**WEST SUSSEX COUNTY COUNCIL
STRATEGIC PLANNING CONSULTATION**

**TO: Arun District Council
FAO: Mrs S Leeson**

SUBJECT: BR/319/11 - COU from residential (C3) to ground floor Chiropractors (D1) with 1st floor residential accommodation to include demolition of existing garage/store & erection of single storey extension.

206, London Road, Bognor Regis, West Sussex, PO21 1AX

SUBSTITUTE SITE PLAN ONLY 10/02/2012

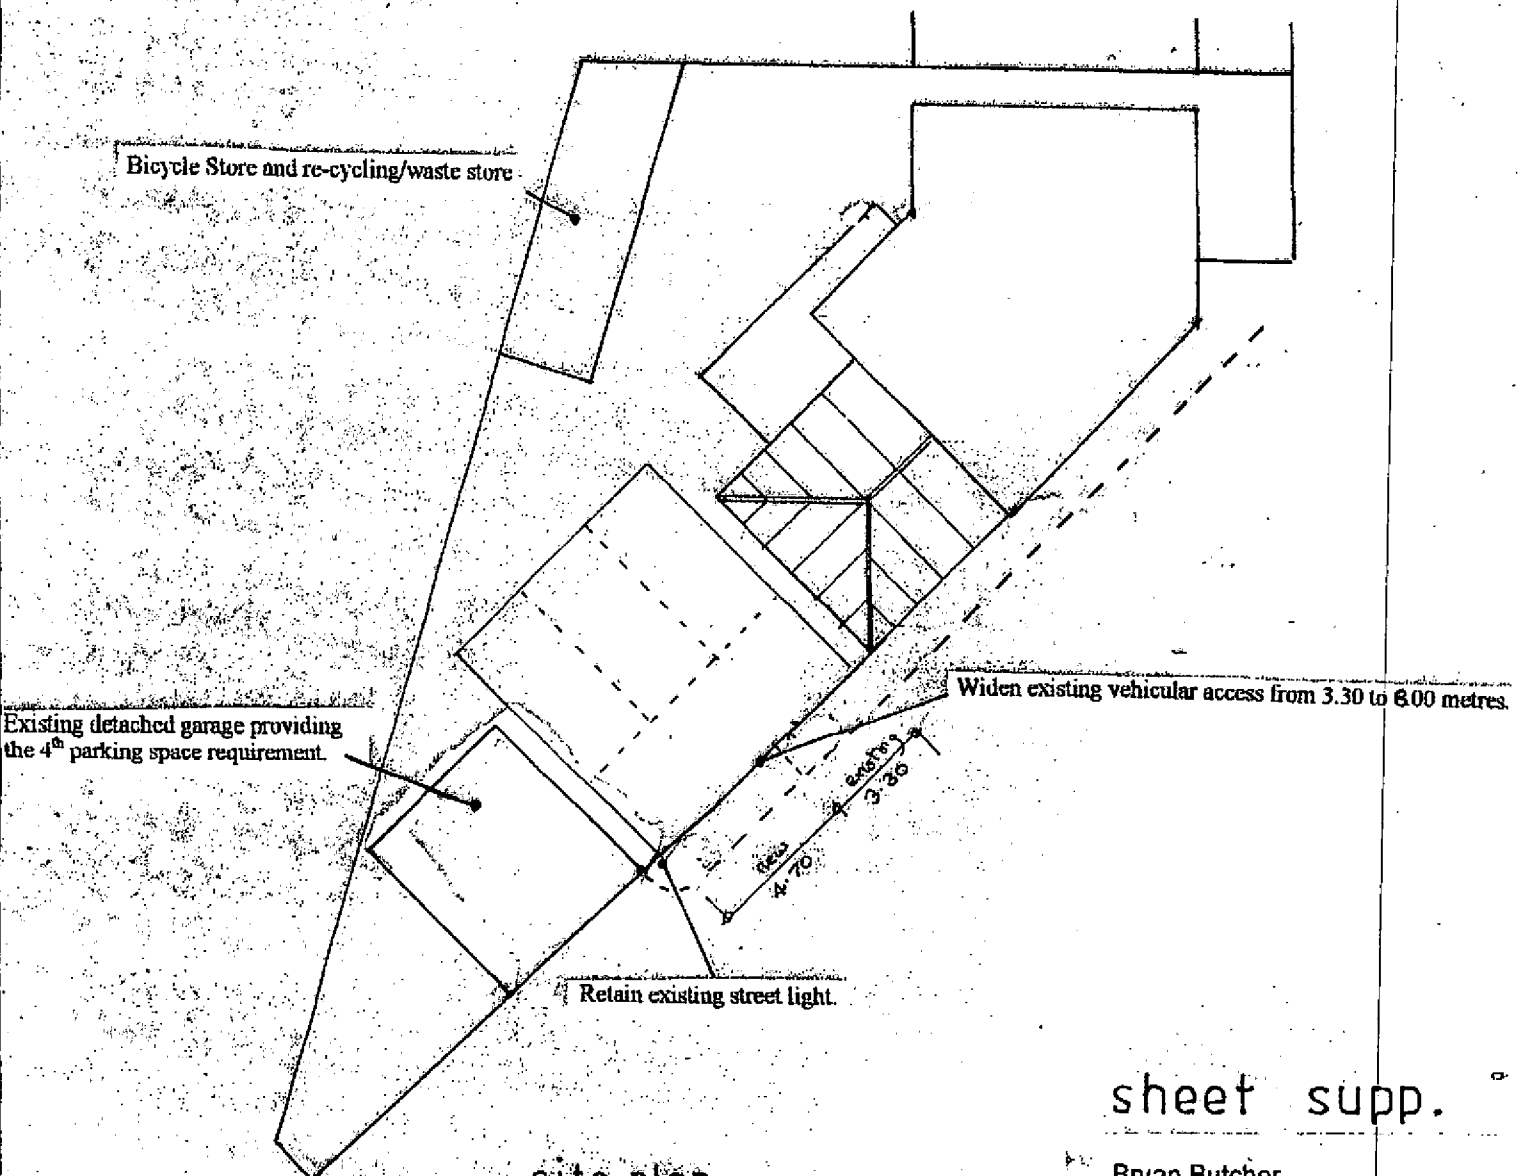
The property already benefits from a 3.3 metre wide dropped kerb access from East Lake and this proposal will see this access widened to the south west to 8.0 metres, this will allow for the creation of three off street car parking spaces. In addition to the three off street spaces the existing garage is to be retained to provide a fourth car parking space. With regard to the latest WSCC appropriate levels of car parking standards we would expect the residential part of this proposal to generate the need for one vehicular car parking space, this can be satisfied by the existing garage as per the Design and Access Statement. This would leave the three off street vehicular car parking spaces for the use of the business. With regard to the latest standards this would appear to fall short of what we would require for a development of this

The off street vehicular parking spaces should measure 2.4 x 4.8 metres and from inspection of the plans provided the size of the proposed parking bays would appear to be appropriate. No turn on site facility is available however giving consideration to similar access arrangements in the vicinity in addition to the access width and appropriate visibility we would not consider this to be of detriment to highway safety.

There are no highway safety concerns with the principle of widening the access to 8.0 metres as visibility appears to be appropriate at this point of access onto East Lake. I have also checked the most recently available verified accident records, which reveals there have been no personal injury accidents in the vicinity of the existing point of access. The works on the highway for the new access must be agreed with the WSCC Local Engineer and carried out under licence. I would also require the driveway area and car parking spaces to be constructed in a bound material and that suitable drainage methods are installed to prevent private surface water running onto the public highway. There is a street lighting column in close proximity to the existing access point but from the plans provided I see no reason why this column can't remain in situ.

If the LPA are minded to approve this application then conditions securing the access, vehicular parking and cycle parking should be included.
